**Subject: 185 Fore Street  
Final Level III Site Plan and Subdivision Application**

# 185 Fore Street

**185 FORE STREET  
RESPONSE TO STAFF COMMENTS ON PRELIMINARY APPLICATION**

(F) BARRIER FREE RAMP DETAILS
N.T.S.

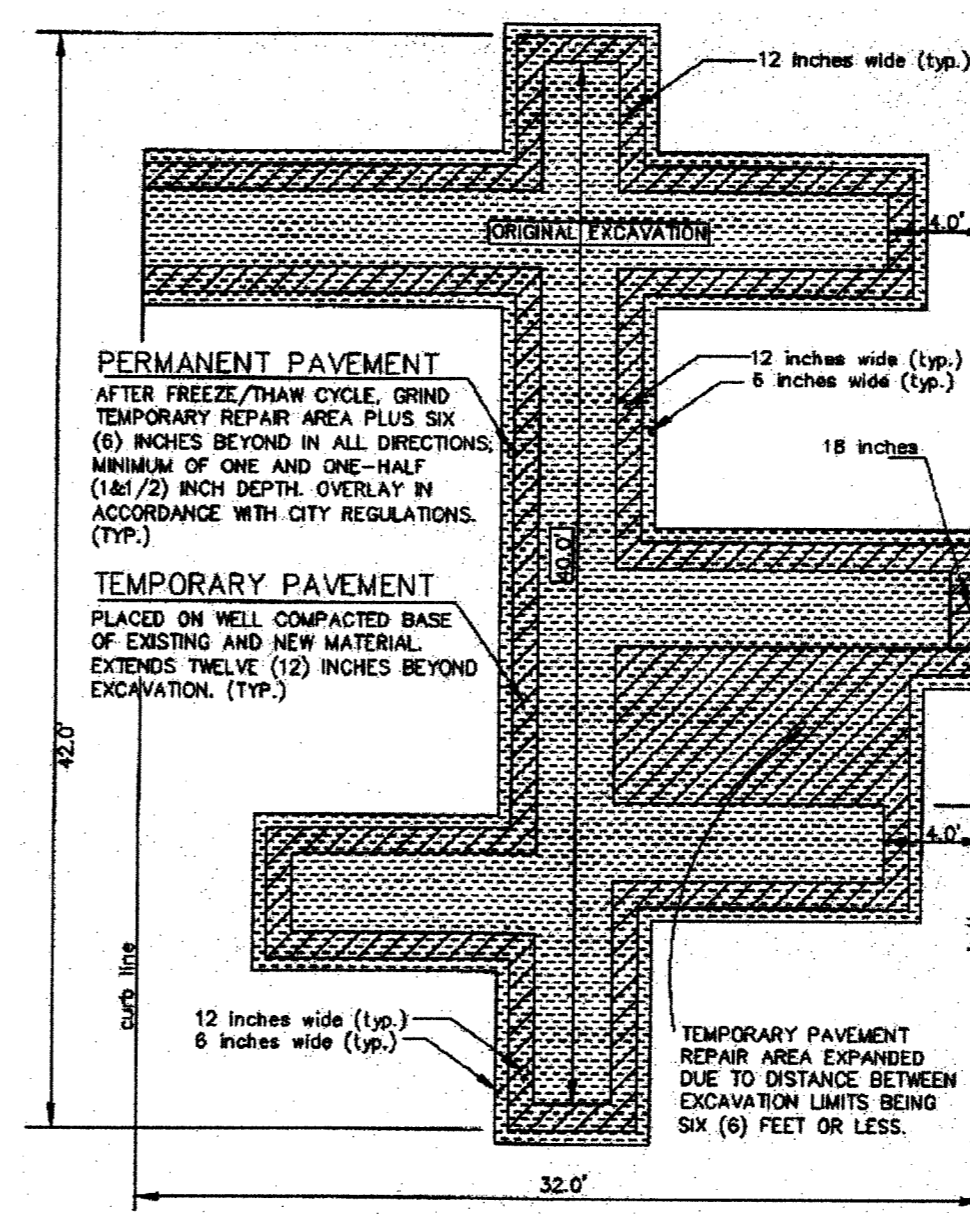
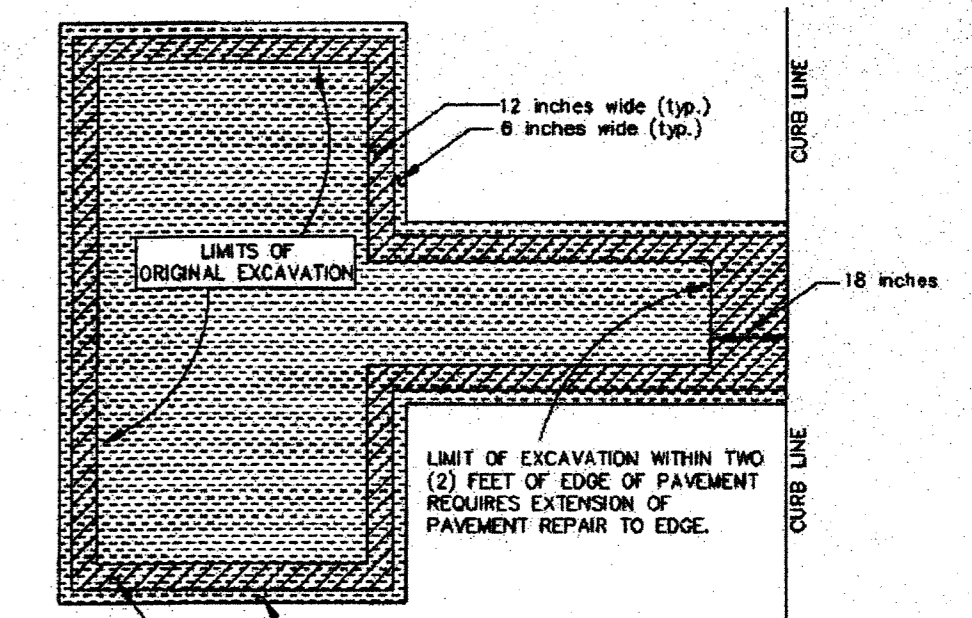
*The proposed ramp to serve the crosswalk at Fore St. is not ADA compliant and therefore not acceptable as shown. City staff is willing to meet with the applicant to discuss options.*

*The ramp to serve across Fore St. (to the pump station) does look like it does not have a 4' landing at the top (unless there is an overhang to the building providing it). If not, it seems the ramp could be slid to the west; that might provide better alignment for people traveling/continuing along India St.*

The ADA ramp configuration has been modified to be compliant with ADA Standards.

As indicated above, the ADA ramp configuration has been modified to be compliant with ADA standards.
